**Consultation Response from KC,  
Highways Development Management**

**2023/91454 Helm Farm, Colnebridge, Bradley, Huddersfield, HD5 0PU**

**Date Responded: 11-9-2023.**

DRAWING TITLE  
ACCESS PROPOSAL

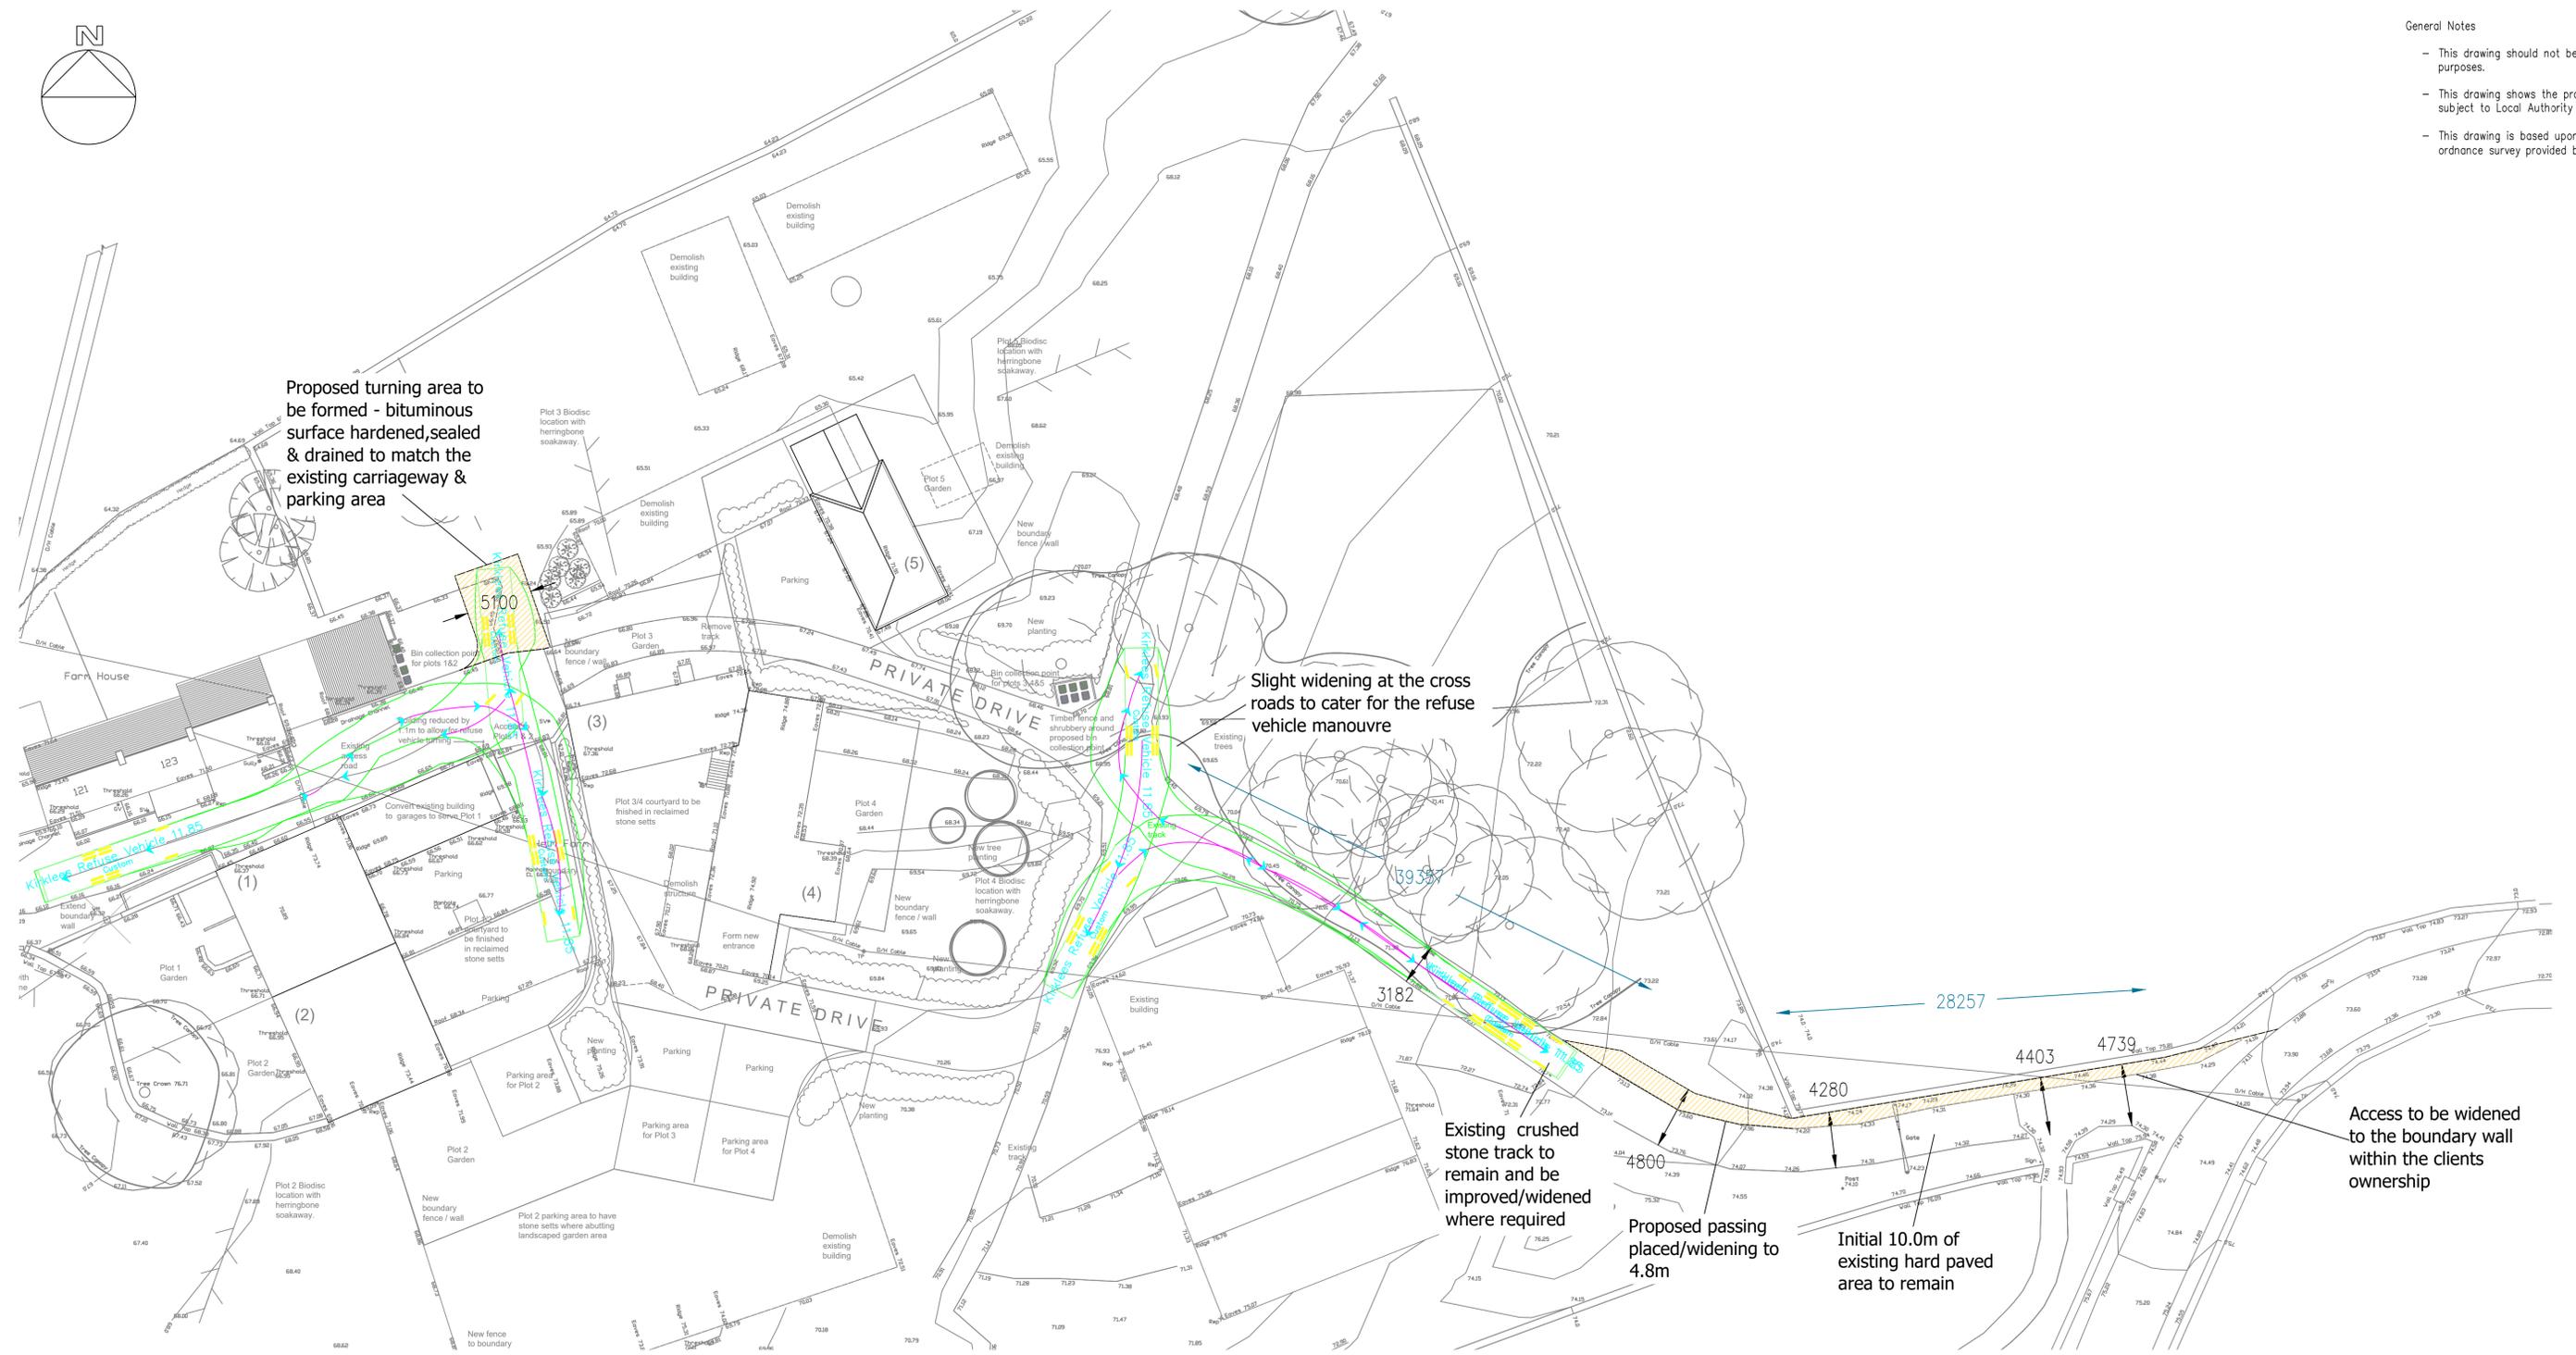
1, No information is provided regarding the condition, width or available passing places of the existing access tracks from Bog Green Lane and Paul Lane. Passing places ( minimum 4.5m in width) should be shown at 45m intervals with good intervisibility' between the spaces.

In this case the part of the existing track is shown to be removed to provide garden to plot 3 which results in there being no through route from Bog Green Lane to Paul Lane. Both means of access from Bog Green Lane to Paul Lane are over 20m in length and emergency vehicle turning therefore needs to be shown to be provided.
